Application No: K/11/22/PL
Site Address: Salamanda 37 Coastal Road Kingston BN16 1SJ
Description of works: Demolition and erection of 1 No detached dwelling. This site is in CIL Zone 4 and is CIL Liable as new dwelling.

Thank you for your internet representation made on 13th March 2022 which has been recorded as an objection with the comments as follows:

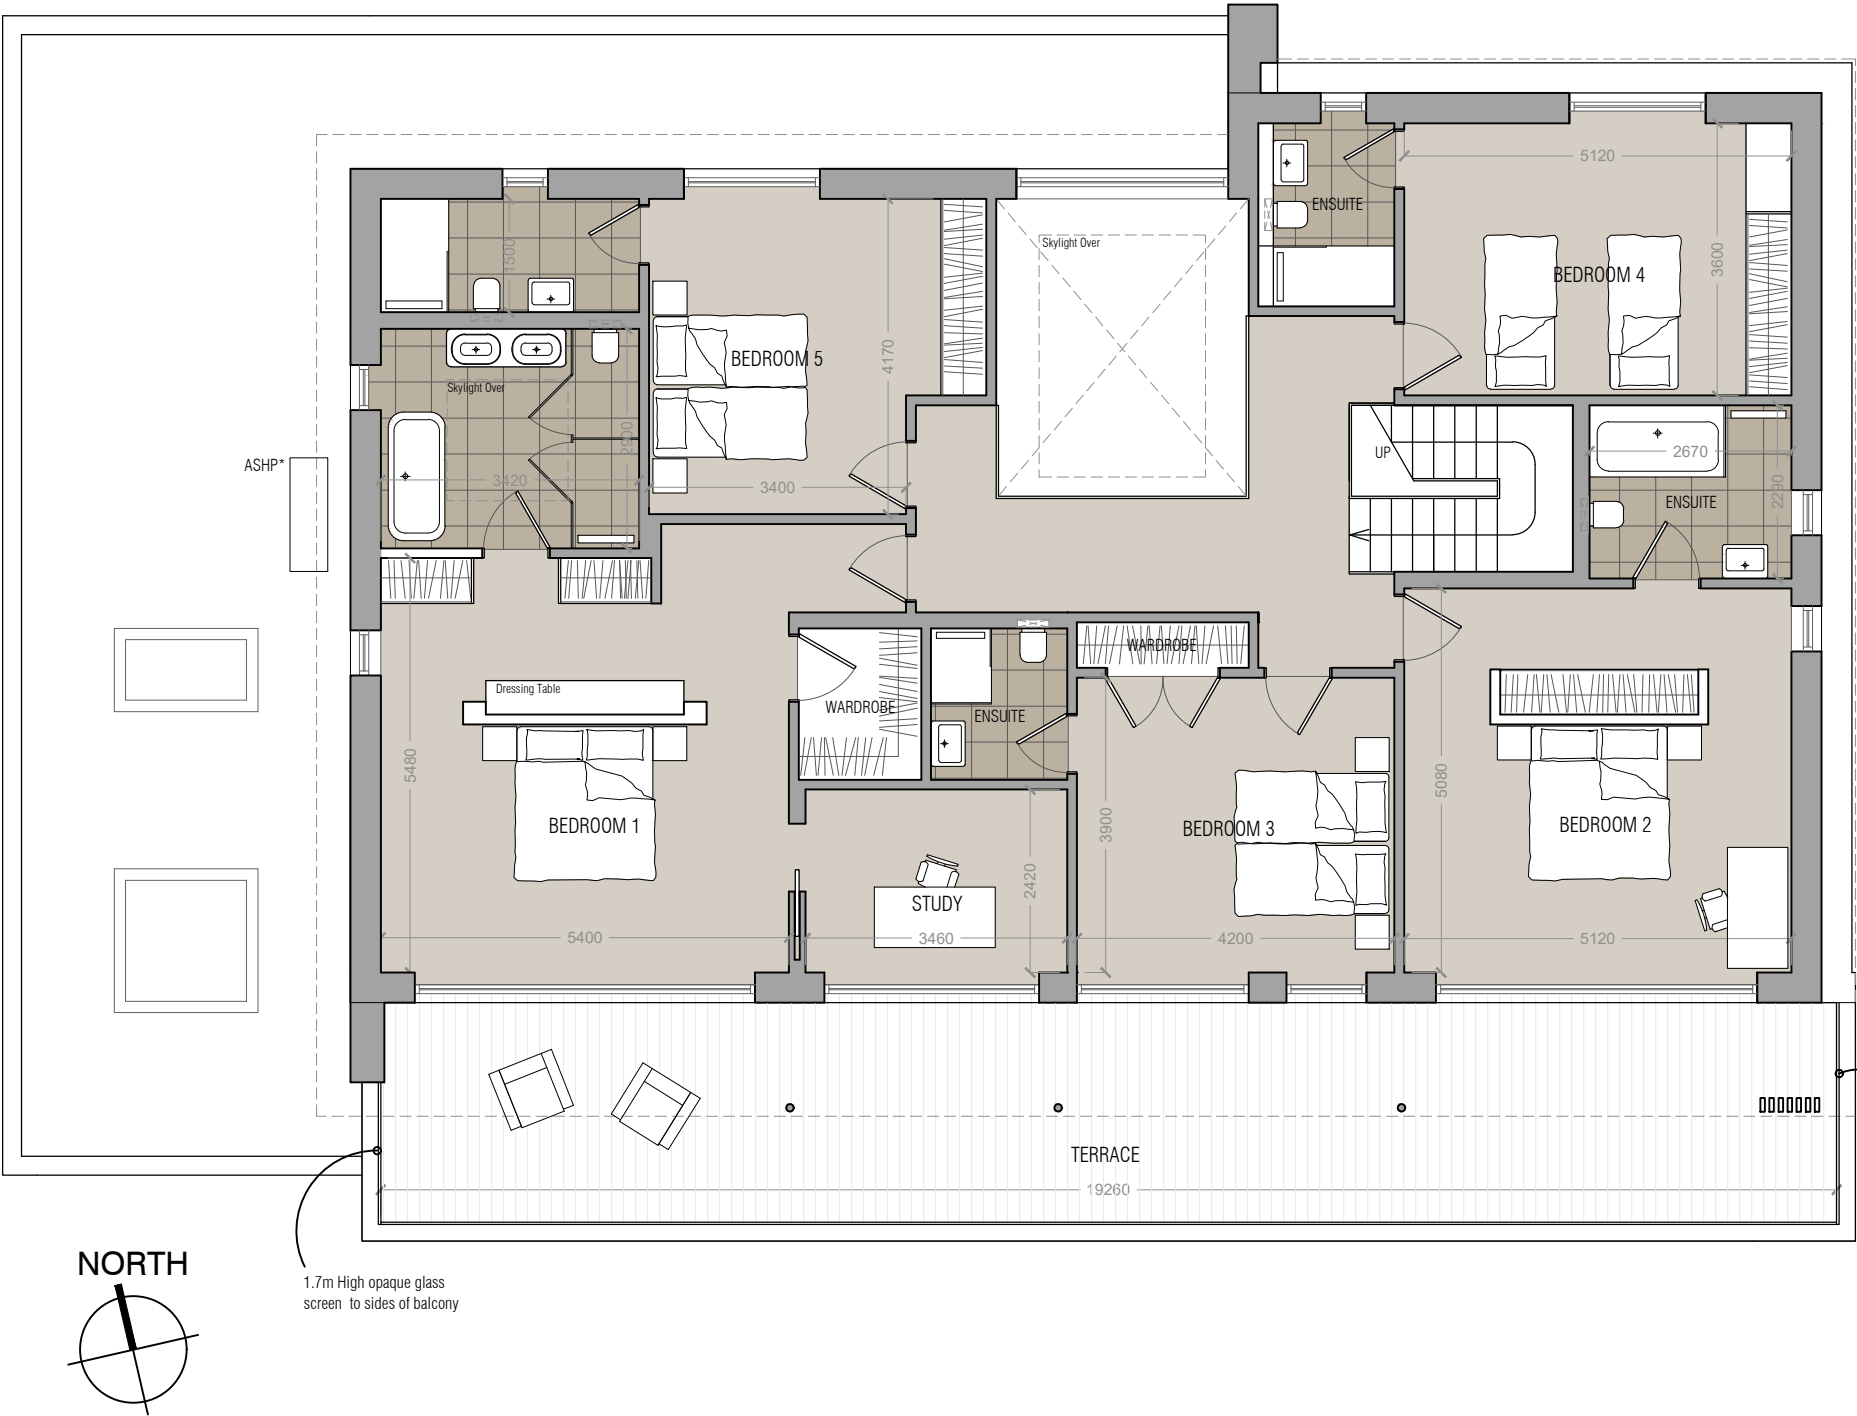
We are broadly supportive of this application, however we are concerned that someone standing on the roof terrace will overlook our swimming pool and hot tub.

This objection could be resolved by having a head-height screen running the full length/width of the East side of the roof terrace.
